Town & Country Planning (Control of Advertisement) (England) Regulations 2007 (as amended)

Application No: AB/59/21/A
Site Address: 61 High Street Arundel BN18 9AJ
Description of works: Installation of 1 x halo illuminated sign

External Fascia Signage

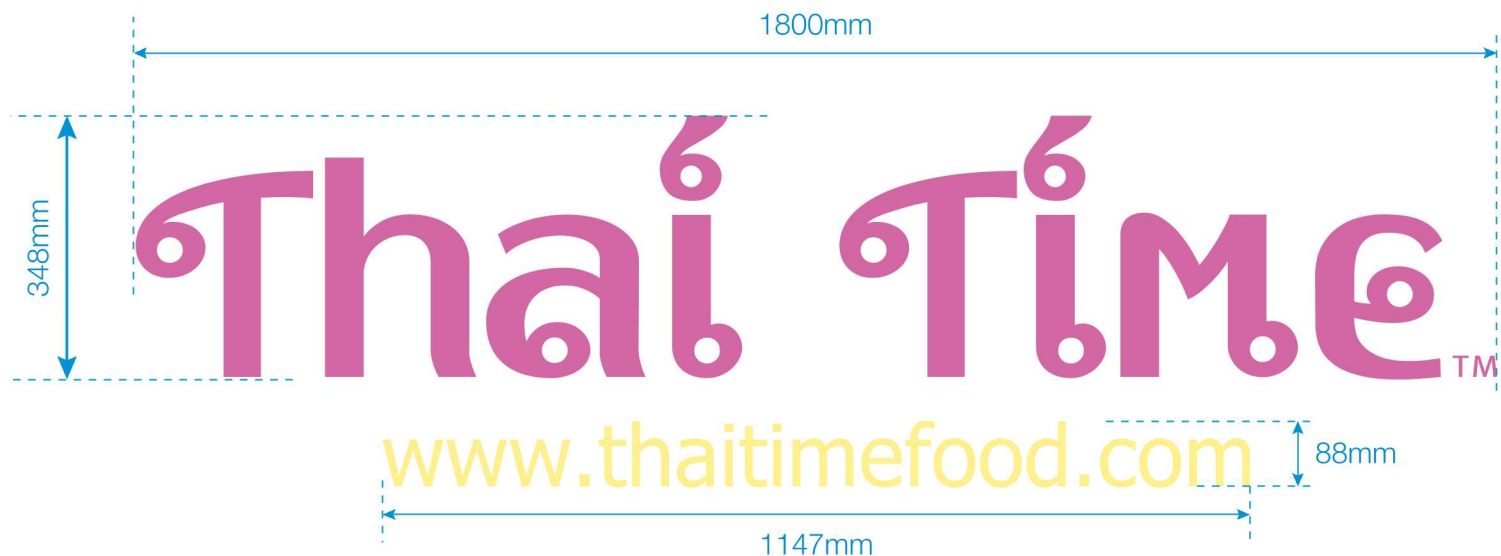
The proposed sign is relatively modest in scale with an appropriate method of illumination and it should not impact adversely on the character or appearance of the conservation area. The proposed colours are a little strident but probably not to a degree that would warrant a refusal of Advertisement Consent.
